From: Thomas Callaway
Sent: 04 March 2015 15:31
To: Planning.Responses
Subject: RE: Planning Consultation on R/31/15/DOC

APPLICATION R/31/15/DOC
NO:

Registered: 09-FEB-15
Site Address: 69 Broadmark Lane Rustington BN16 2HL

Application for approval of matters reserved by condition imposed under R/243/14/PL relating to Conditions 3 & 7 concerning surface water drainage & schedule of materials and finishes.

Fig. 2 Proposed site layout.

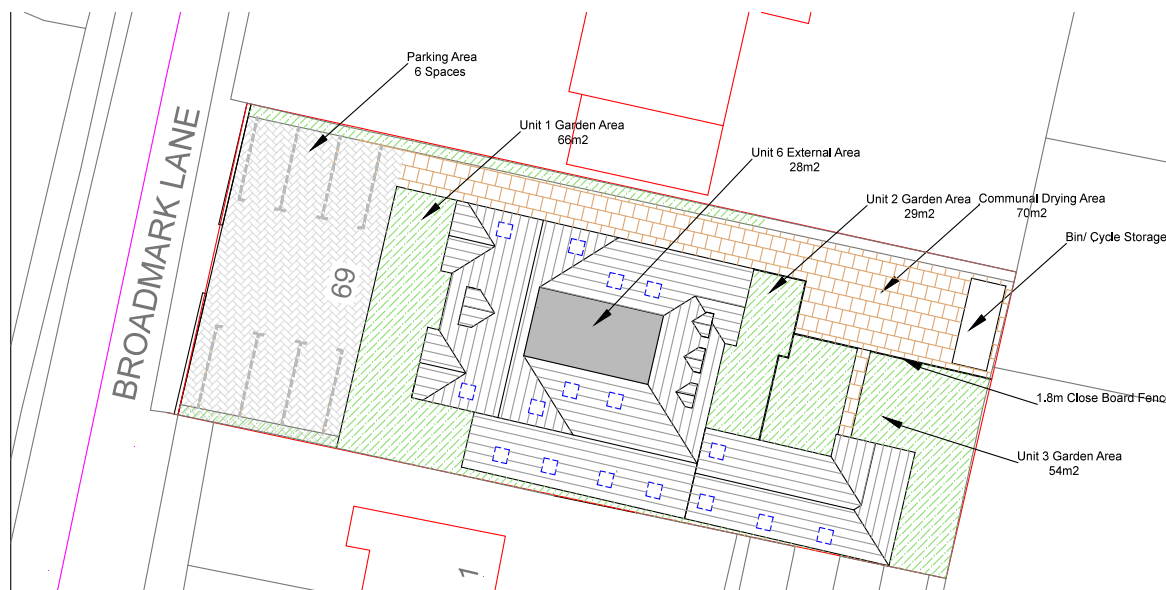
It is noted that the proposal reduces the impermeable area from the current extent.

The soakaways for the proposals should be designed as stated in the condition. The condition should not be discharged until the design of the soakaway has been informed by winter groundwater monitoring, percolation testing and calculations showing that the 1 in 100 year storm event plus 30% is stored without flooding. Construction drawings with levels will be required.
